GG119 ROAD SAFETY AUDIT RESPONSE REPORT

Project Title:	Proposed Warehouse, Cooper Bridge, Mirfield
Project Team:	John Cotton Group Ltd
RSA Report Stage	Stage 1
RSA Organisation:	Meraki Alliance
RSA Report Reference:	MAL/CPMRSA1Rev0
RSA Report Issue Date:	25 March 2025
Report Title:	Stage 1 Road Safety Audit Response
Reference:

This Road Safety Audit Response Report relates to a Stage 1 Road Safety Audit carried out on the proposed highway works required to access a proposed development of a warehouse on the former Cooper Bridge waste water treatment works, near Mirfield, Huddersfield (Planning Application Reference 2023/92448).

Drawing Title:
SITE ACCESS GENERAL ARRANGEMENT

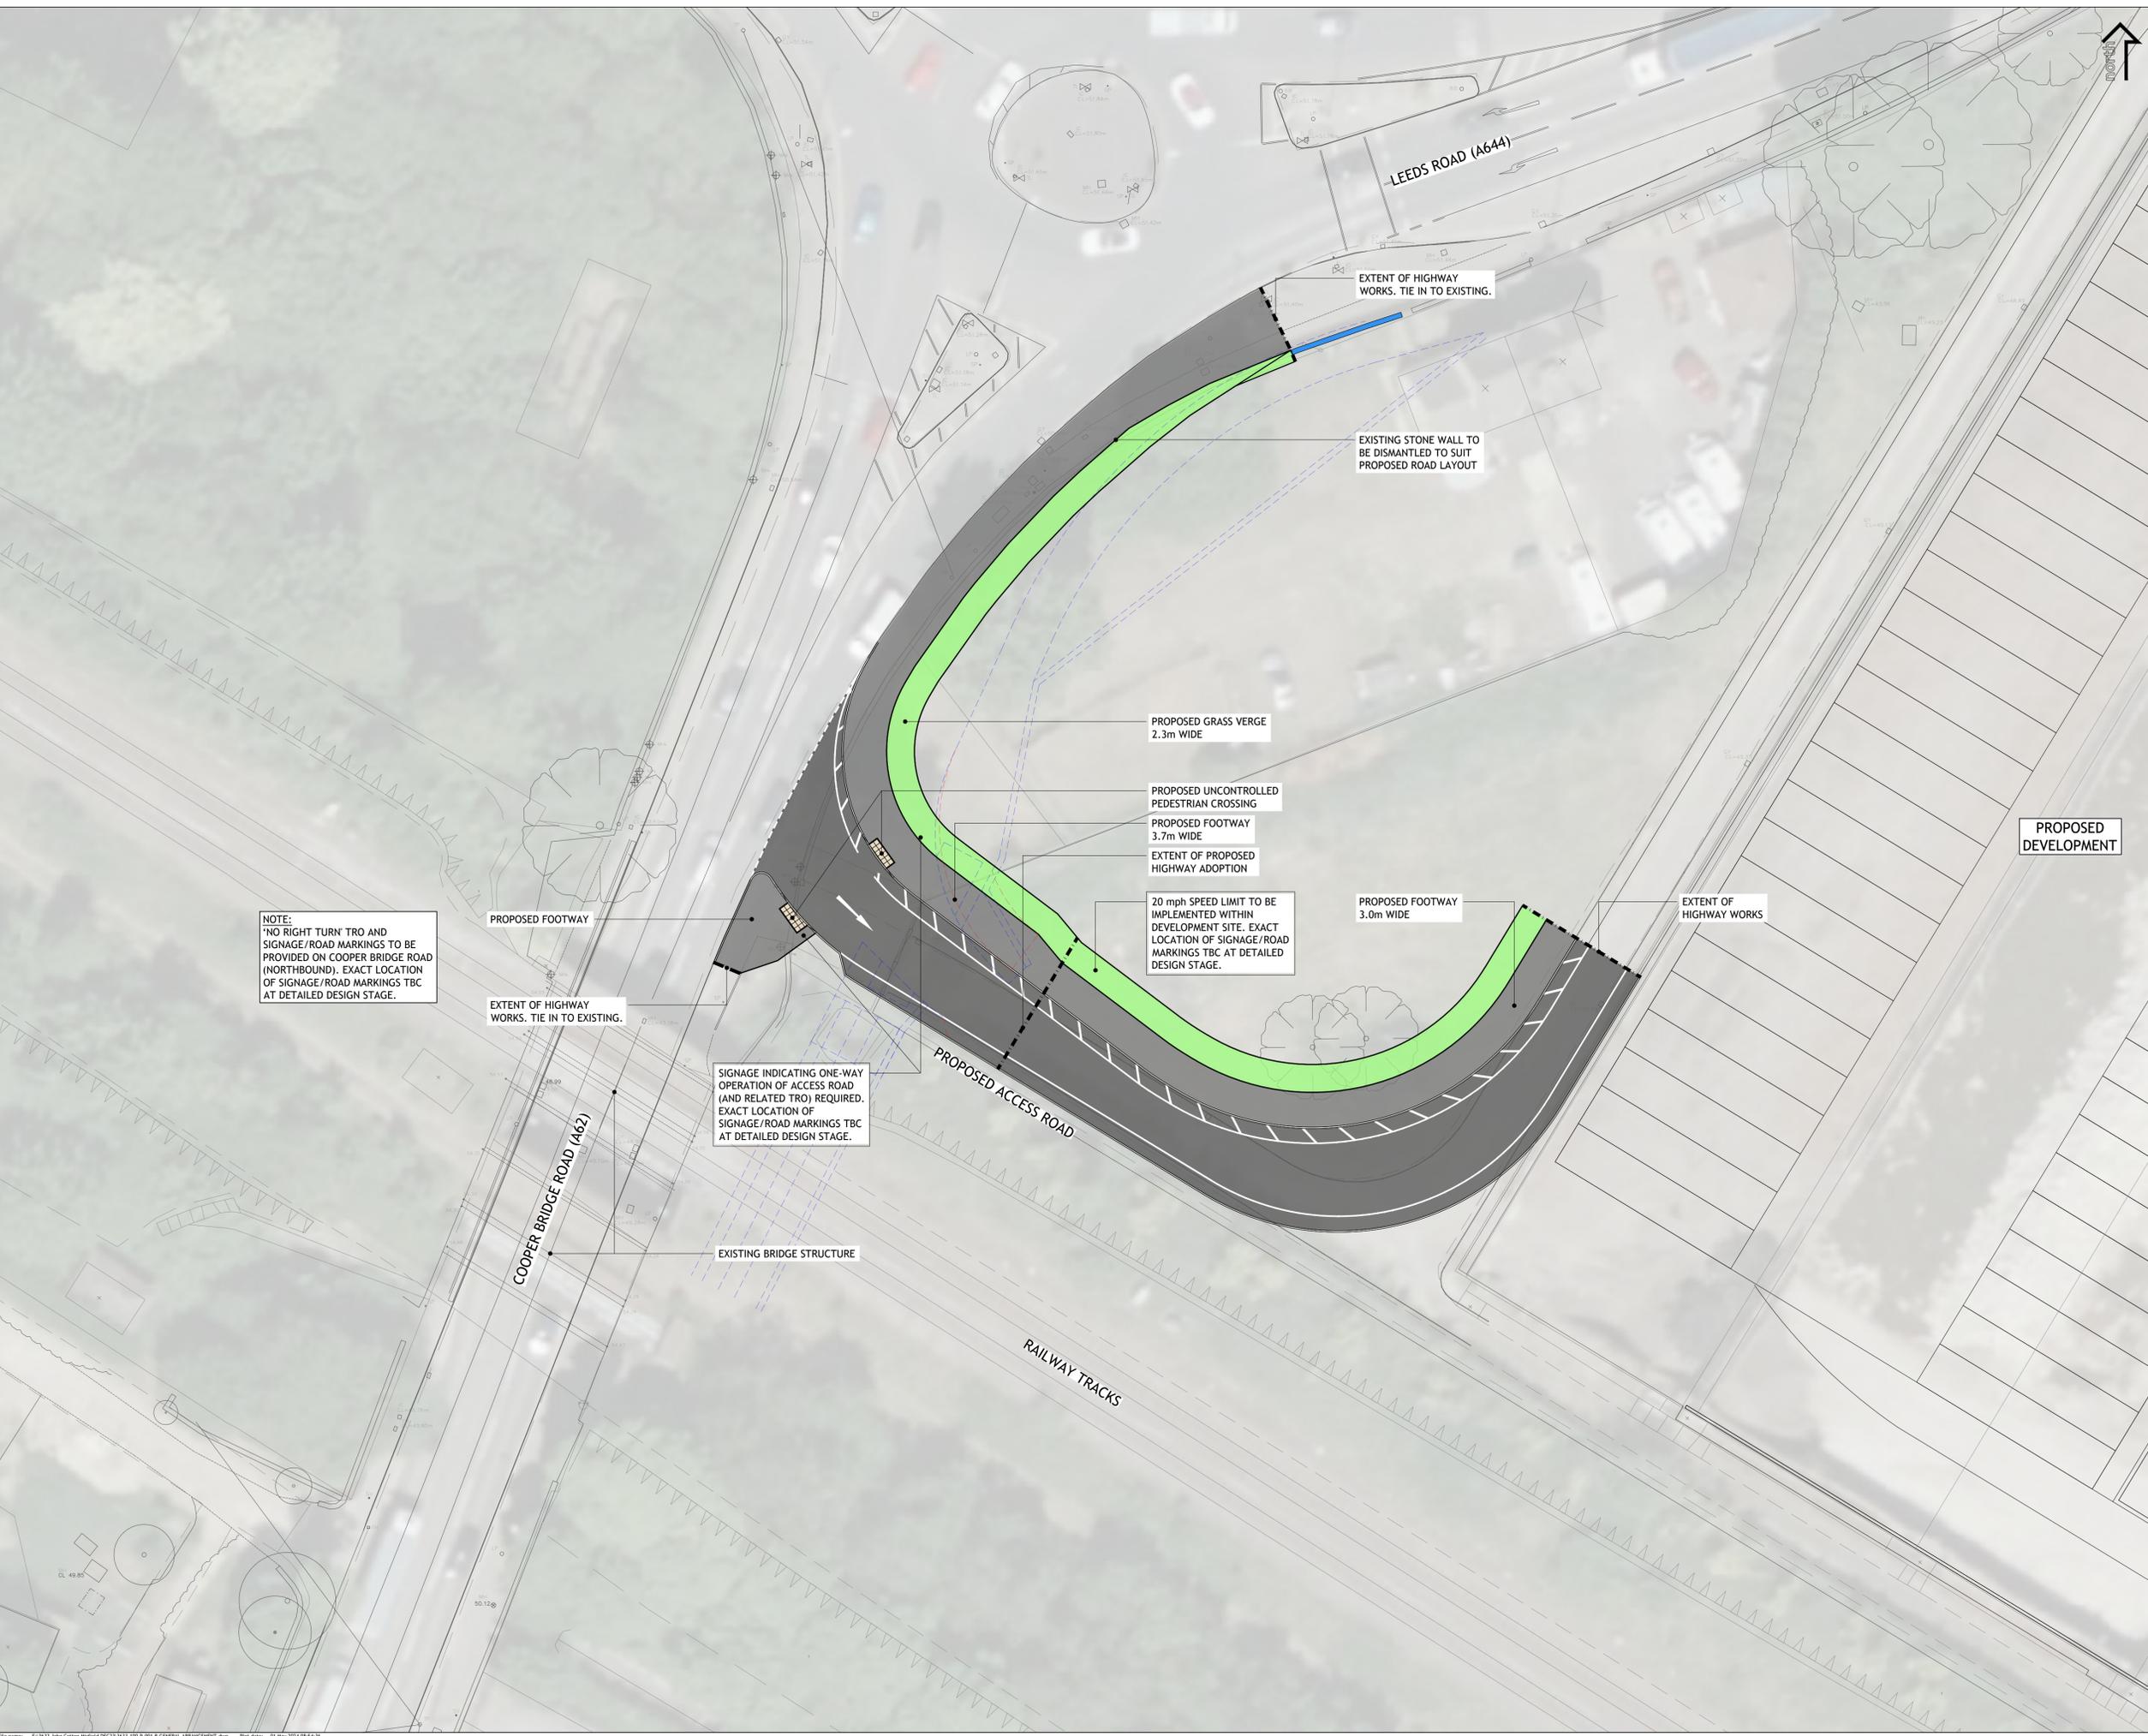
Location: Huddersfield Road Access.

Summary: Sub-standard visibility at uncontrolled crossings will increase the risk of pedestrian/vehicle collisions.

Detail: It is proposed to construct a new access onto Huddersfield Road, as part of these works an uncontrolled crossing will be provided. The details provided within the brief indicate that a maximum visibility splay of 1m x 17m can be achieved on the eastern crossing point. CD 143 Table E/5.2 states that the minimum measurement for a set-back (X distance) must be no less than 1.5m and the Y distance must be based on the speed of approaching vehicles. It is accepted that speeds will be low for HGV's turning into the site, but cars may well turn in at higher speeds resulting in an increased risk of pedestrian/vehicle collisions.

It is recommended that a minimum of 1.5m x 22m is provided which complies with DMRB set back distances and a stopping sight distances for approach speeds of vehicles of 20mph (MFS).

Summary: *Sub-standard central pedestrian refuges will increase the risk of pedestrian/vehicle collisions.*

Detail: It is proposed to construct a new uncontrolled crossing over Leeds Road with a new central pedestrian refuge. It is noted that this refuge is narrow and as such a pedestrian with a push chair or with young children may not be able to be fully accommodated within the narrow refuge and as such will increase the risk of being struck by a passing vehicle increasing the risk of injury.

It is recommended that a minimum of 2m wide pedestrian refuge is provided.

Recommendation accepted.

The proposed arrangement has been identified in consultation with the local highway authority in consideration of the planning application to date.

Notwithstanding this, the sketch below demonstrates that a pedestrian visibility splay of 1.5m x 22m can be achieved at this crossing.

The RSA Recommendation and Design Team Response are accepted.

The above sketch confirms that a 1.5x22m pedestrian visibility splay will be available to motor-traffic, when measured to the nearside edge of the mandatory cycle lane, which is in accordance with the RSA recommendation.

In addition to this, the Design Team have provided the following sketch that demonstrates that a 1.5x17m+ pedestrian visibility splay will be available to the nearside wheel-track (taken as min. 0.5m from kerb edge) of cyclists travelling in the cycle lane. This is in accordance with an SSD of 17m, as set out in LTN1/20, based on a 20kph cycle design speed, which is considered to be robust for a left turning cyclist turning into the junction.

Recommendation rejected.

Through discussion with the local highway authority in preparing the proposals, it was highlighted that a clear carriageway width of 4.1m is required for the eastbound lane passing the proposed island. To accommodate the existing westbound lanes, an island with a width of 1.5m is therefore the maximum that can be achieved. While narrower than the width identified as desirable by CD143 (para E/4.7), the proposed width meets the absolute minimum requirements, and is considered to represent a reasonable provision (and benefit) compared to the existing situation, where no island exists.

The RSA Recommendation is rejected, and the Design Team Response is accepted.

It is also noted that with the wider Cooper Bridge Improvement scheme that is currently being developed, controlled crossing facilities are proposed across Leeds Road within the amended traffic signal arrangement. Therefore, this will provide an enhanced crossing facility on Leeds Road in future, which will further enhance the crossing provision on Leeds Road.
